Your Reference: MP 10_0050
Our Reference: NCA/4/2010
Contact: Brad Delapierre
Telephone: 9806 5393
Fax: 9806 5901

24 November 2010

**Major Project 10_0050 – Westmead Millennium Institute -166 to 174
Hawkesbury Road ,Westmead**

FLOOR PLAN
 LEVEL 00 - LOWER GROUND
 DRAWING NUMBER: DA-D-00
 ISSUE: 8

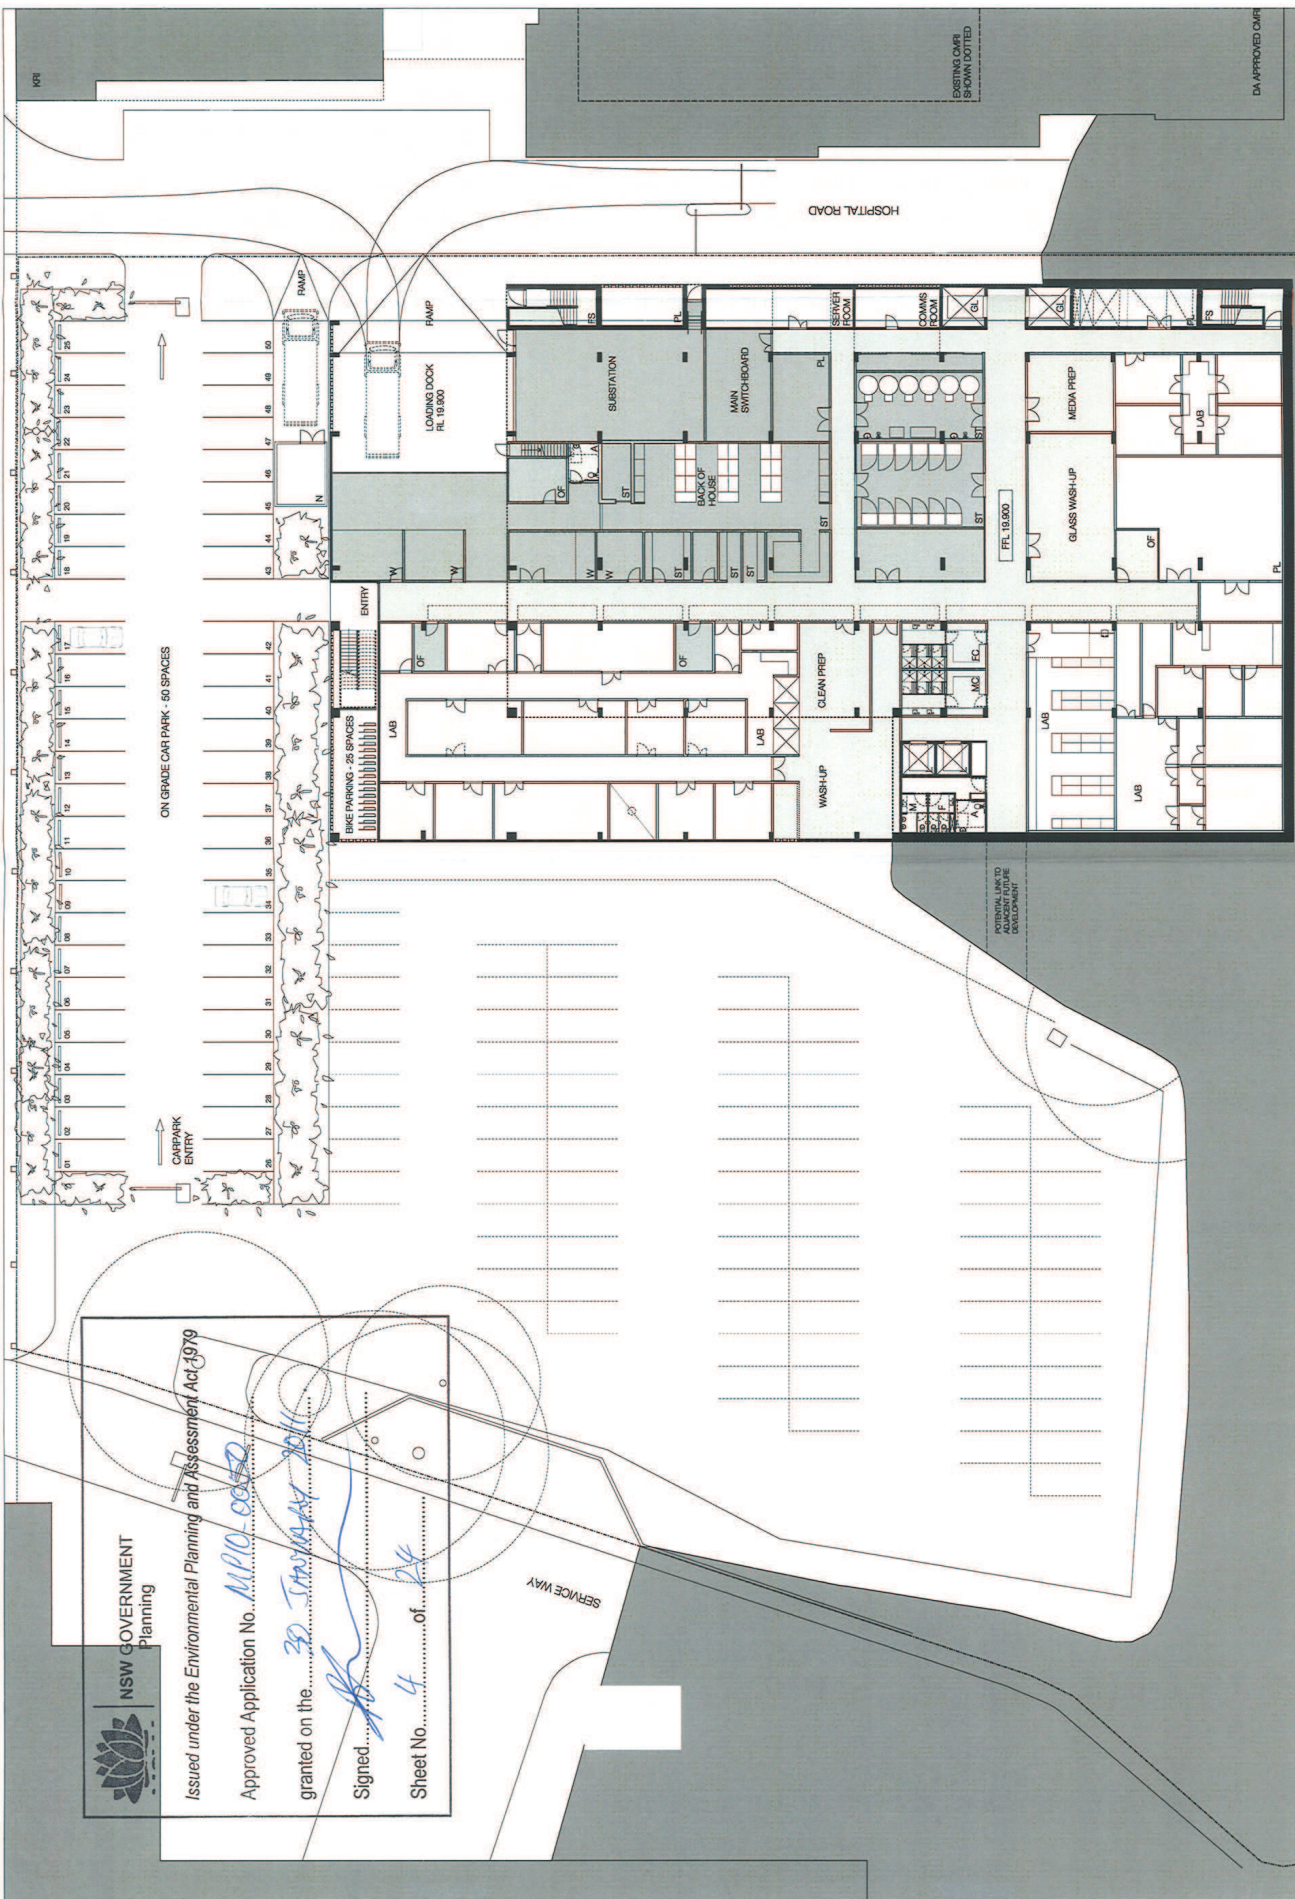
1. 50 off-street parking spaces are to be provided, permanently marked on the pavement and used accordingly. The dimensions for parking spaces and aisle width to be in accordance with AS 2890.1-2004 (minimum of 2.4m wide x 5.4m long clear of columns plus 300mm clearance adjacent walls & 6.2m aisle width minimum).

2. 25 bicycle spaces for staff & visitors, as shown on the plan, to be provided including change rooms with toilets, shower facilities & lockers.
3. Vehicle access points to the carpark that can be accessed from Hawkesbury Road, Westmead to be provided accordingly. Entry to the site & carpark to be provided via the service road to the south (for WMI vehicles only) and exit to the north on to Hospital Road.

4. Traffic into & out of the carpark to be a one-way traffic movement (from southern end to northern end) and should be marked on the pavement with directional arrows.

5. The existing vehicle access point located centrally along the site's Hawkesbury Road frontage to be removed upon construction of the development site.

SOUTH ELEVATION
DRAWING NUMBER
DA-E-01
ISSUE
6

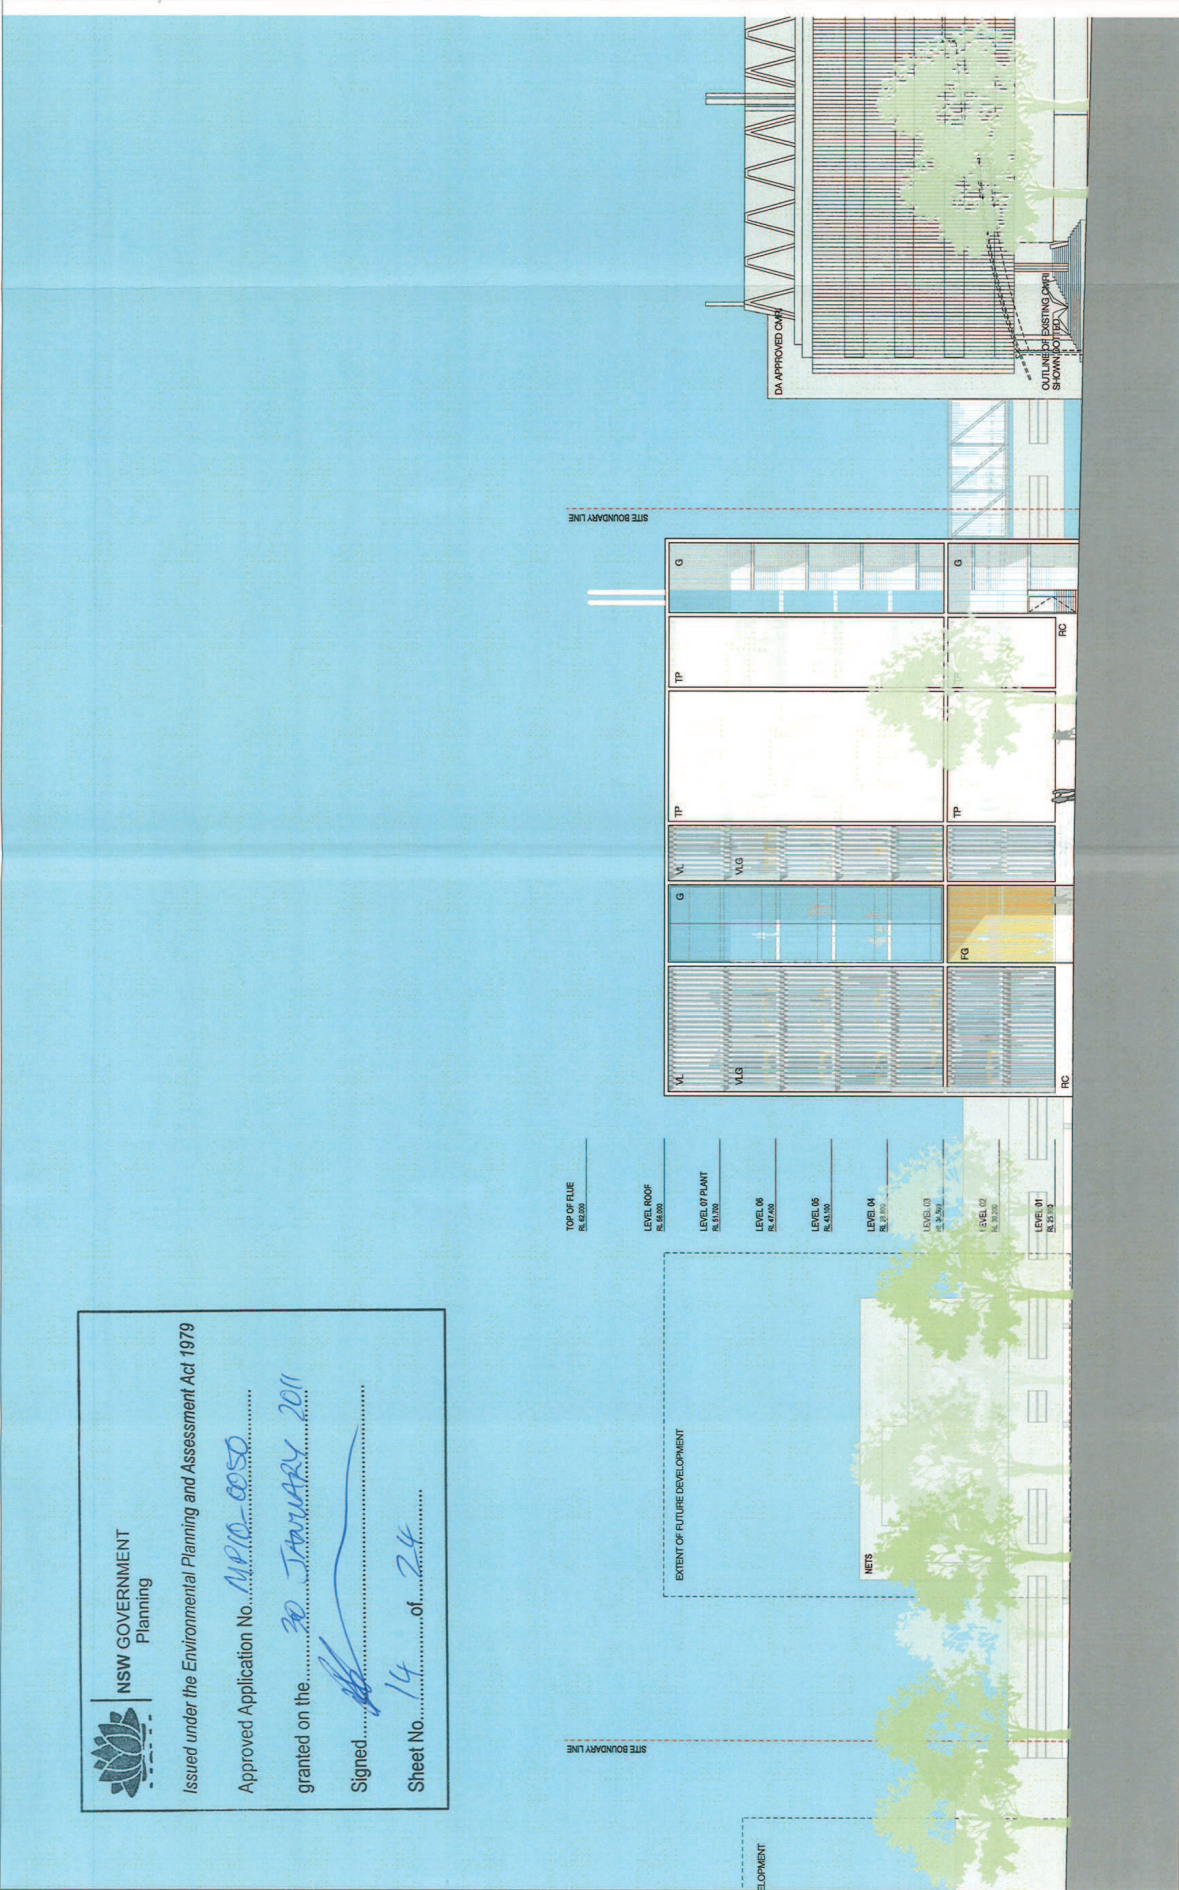
Given that the eight storey height of the building is above the bulk and scale of surrounding development further consideration should be given to architectural treatments to minimise the perceived bulk and scale of the development. This could include recessing the upper levels of the building.
